Your Ref	SSD-80904224
Our Ref	NCA/7/2025
Contact	Douglas Bennett
Telephone	02 9806 5405
Email	dbennett@cityofparramatta.nsw.gov.au

COUNCIL SUBMISSION TO REQUEST FOR ADVICE ON EIS – RESIDENTIAL FLAT BUILDING WITH IN-FILL AFFORDABLE HOUSING AT 93 BRIDGE ROAD, WESTMEAD

Appendix 1 – Detailed Comments

DOCUMENT INFORMATION
Swept Path Analysis
Basement 1 - Car Space 10 - Entry & Exit
FILE NAME AG0898-2-d01-v06.dwg
SHEET AG_SP01

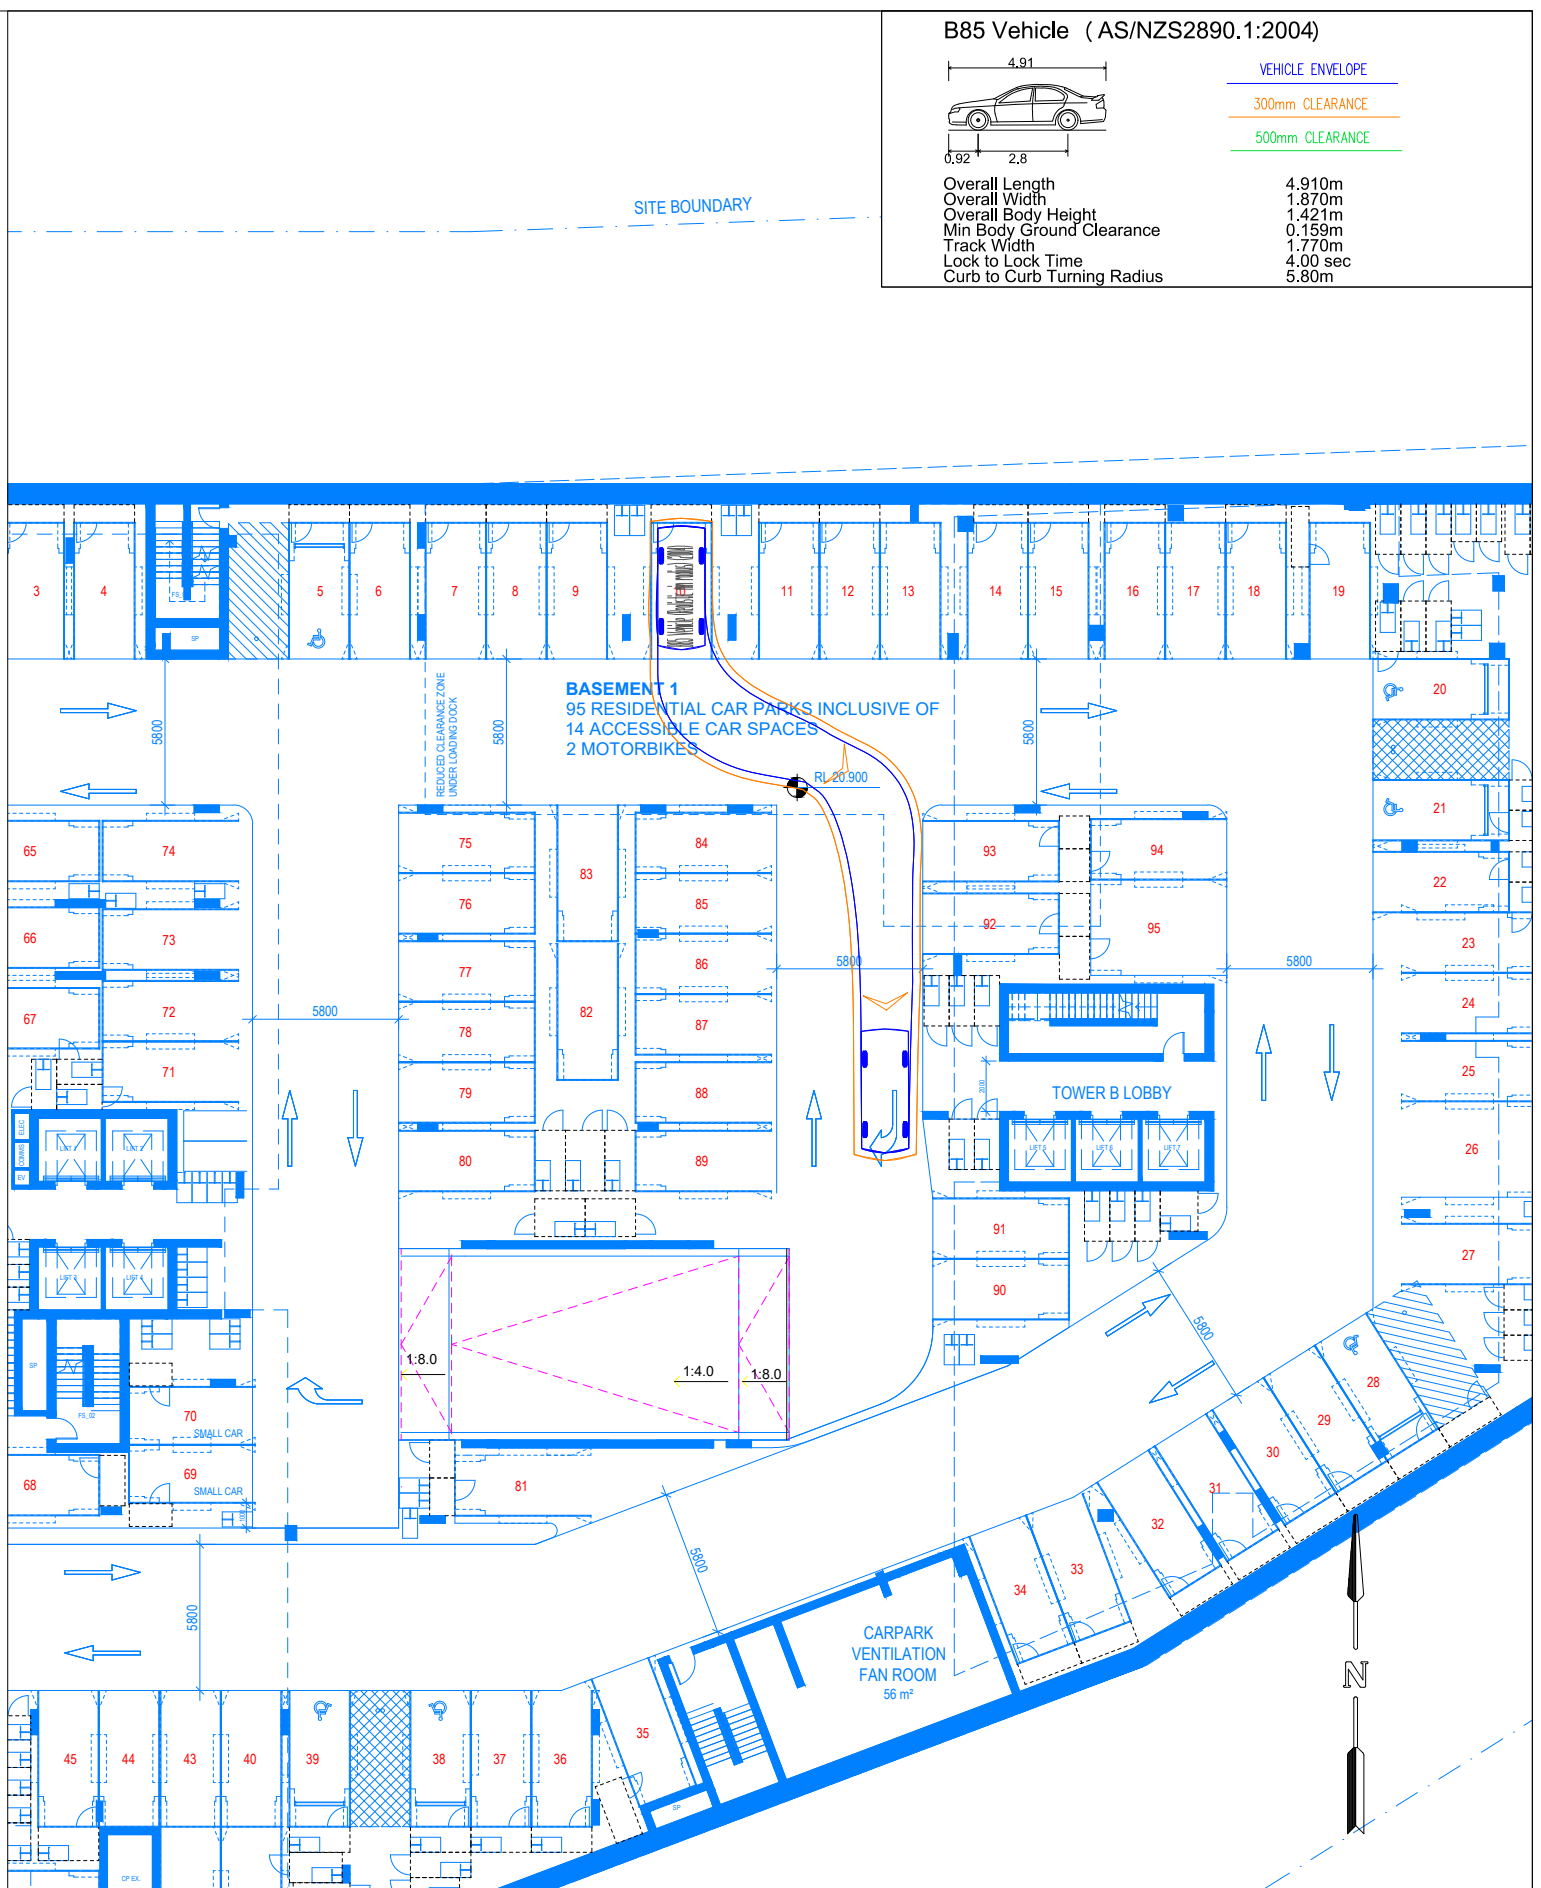
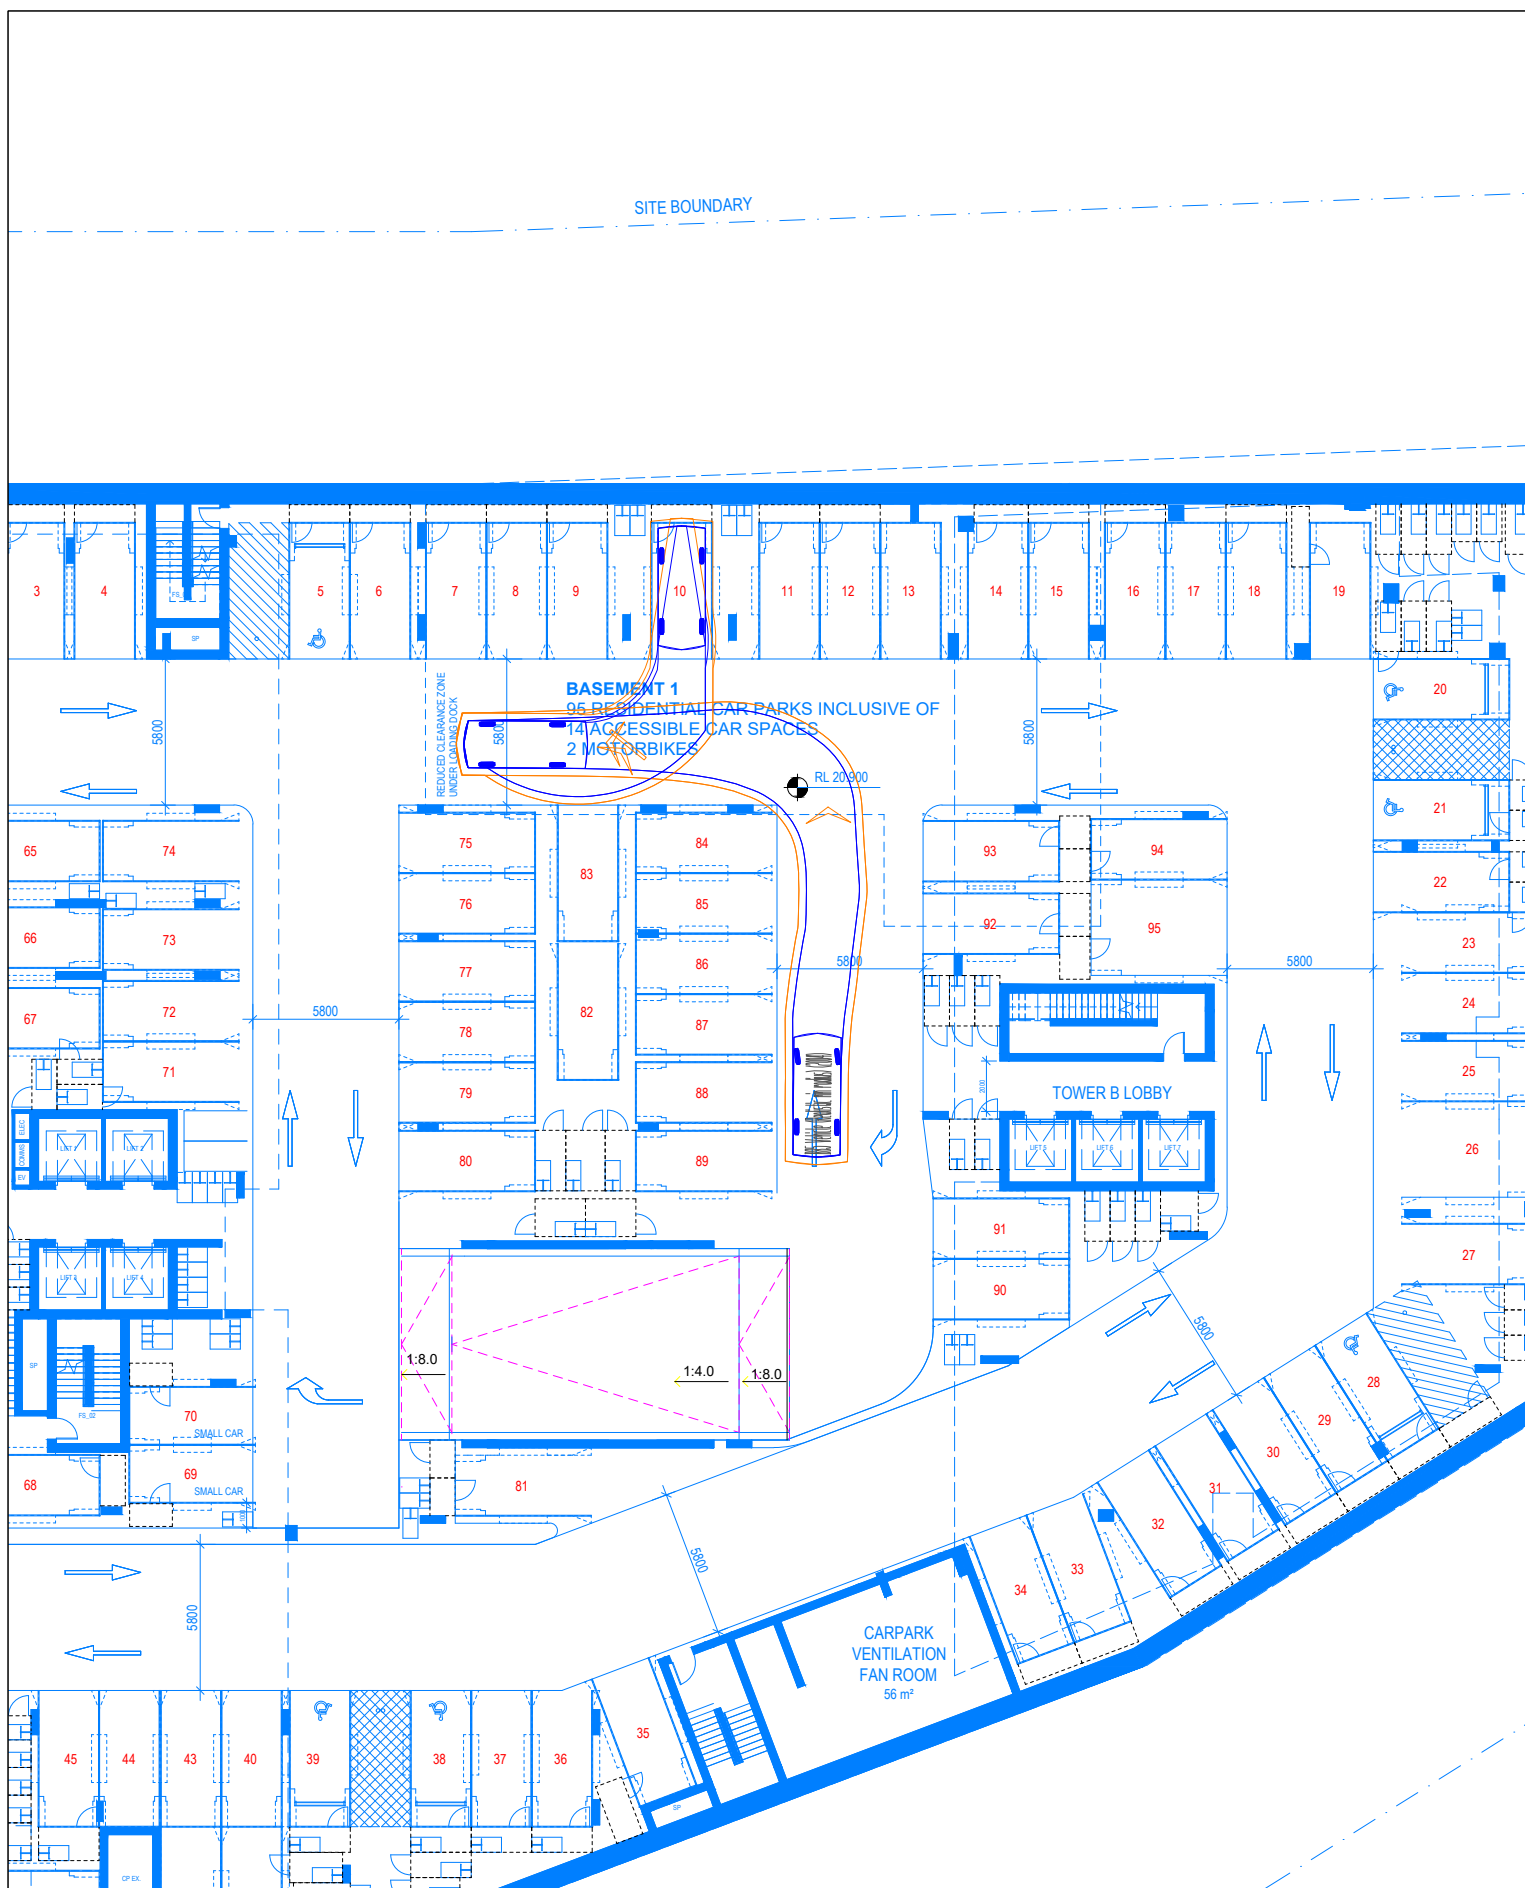
Council notes that parking spaces notated as 7, 8, 9, and 10 on each basement level are adjacent to columns which may obstruct access to these spaces. The columns appear to be reducing the aisle width to between 5.8m and 5.7m. As per the Australian Standards, where

the parking aisle is obstructed on the opposite side to the parking spaces, the aisle width is to be a minimum of 6.1m. Either additional width is to be provided, or swept paths should be provided to demonstrate that access to these spaces will be possible without an excessive number of manoeuvres.
